Rezoning Transportation Analysis

Petition Number: #2022-089

Date	Description
11-28-22	First Review (TM)
01-25-23	Second Review (TM)

RZP-2022-089

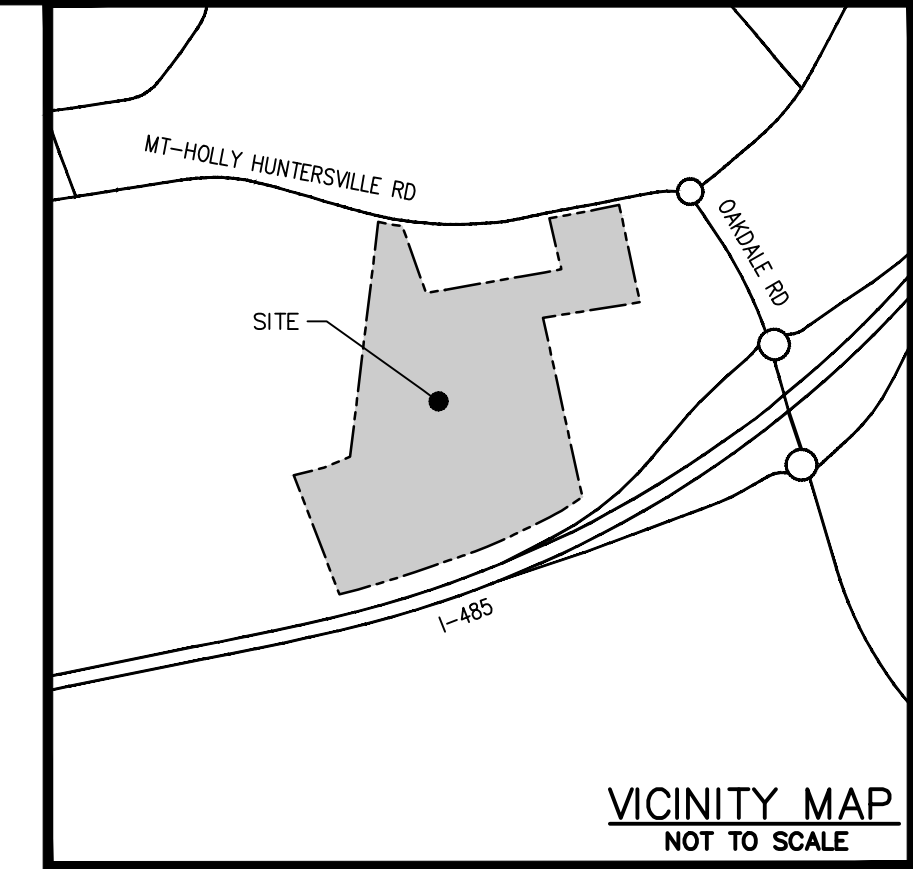
1. **Curblines:** The proposed zoning district has a setback measured from back of the existing or proposed future curblines.
 - a. **Mt Holly Huntersville Road:** The future location of curb and gutter is measured at 30-feet from the centerline of the roadway to the BOC.

Label and dimension the curb and gutter from the centerline for each road on the site plan.

7. Site plan and conditional note(s) revisions are needed to commit private street A, B & C as public roadways. Public street C to stub to the western property line for a future roadway connection. The public roadways are to be designed to CLDSM standards U-03 to accommodate on-street parking. The Right-of-way, curb line and sidewalk are to be dimensioned from the roadway centerline. Add a conditional note committing to the construction of each public roadway.

Clarifying Comment (01-25-23): Add a conditional note committing to the construction of each public roadway. Identify each roadway as U-03 on the site plan and in the conditional note.

8. **Outstanding Comment from 11-28-22:** Site plan and conditional note(s) revisions are needed to label roadway "B" site access as right-in right-out and roadway "A" site access as full movement. A right-turn lane is required at site access B, site plan shall label and dimension turn lane. A right-turn lane and left-turn lane is required at site access A, site plan shall label and dimension turn lane.

Clarifying Comment (01-25-23): Site plan and conditional note revisions are need to show turn lane improvements as outlined above on the site plan. The site plan shall label and dimension the components of the turn lane. Add a conditional note committing to the turn lane improvements. Coordinate with NCDOT on turn lane storage length requirements.

12. Revise site plan to construct a 12-foot multi-use paths on Mt Holly Huntersville Road. The site plan shall label and dimension both items from the back of curb and gutter and road centerline. The entire facility must be outside of the right of way and within a public access easement. Add conditional note committing to construction and maintenance of the 12-foot multi-use paths on Mt Holly Huntersville Road.
